SF2012/010916/1; CR2012/005956; WST11/000132/02

MP10_0157 Exhibition of Environmental Assessment for Bodangora Wind Farm

Thank you for your letter received 6 June 2012 referring the Environmental Assessment (EA) for the above project to Roads and Maritime Services (RMS) for comments.

Figure 3: Swept Path - Intersection of Mudgee Road and Gillinghall Road

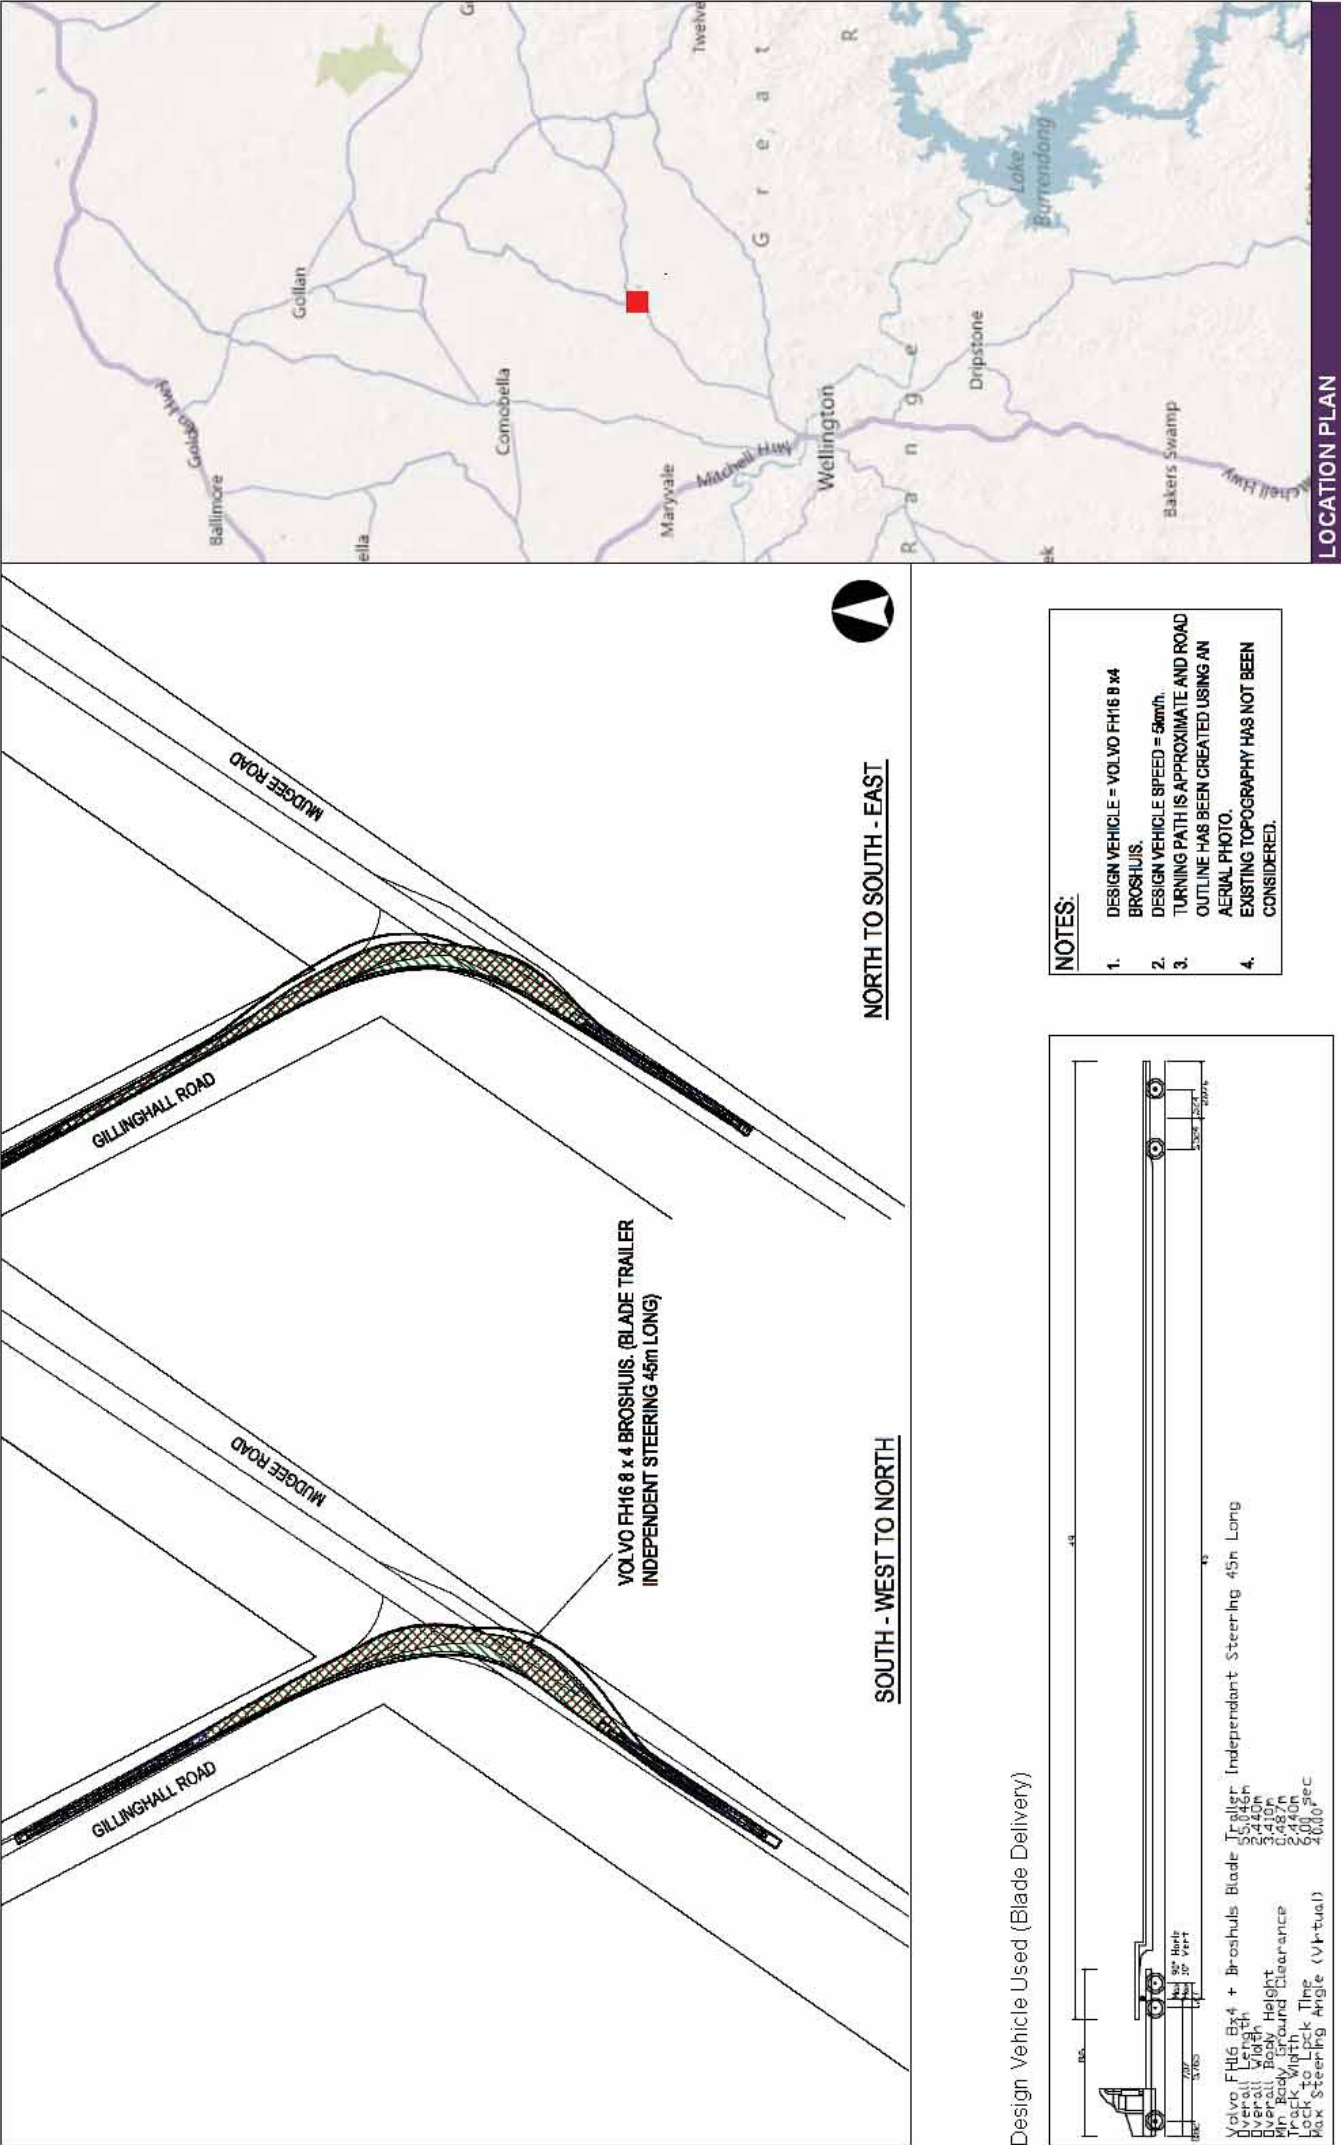
- The design vehicle used in Figure 3 of Attachment K is shown as 45 m long in the diagram and as 55 m long in the key. The proponent is to confirm that the swept path analysis was based on a 55 m vehicle passing through the intersection of Goolma Road (MR233) and Gillinghall Road.
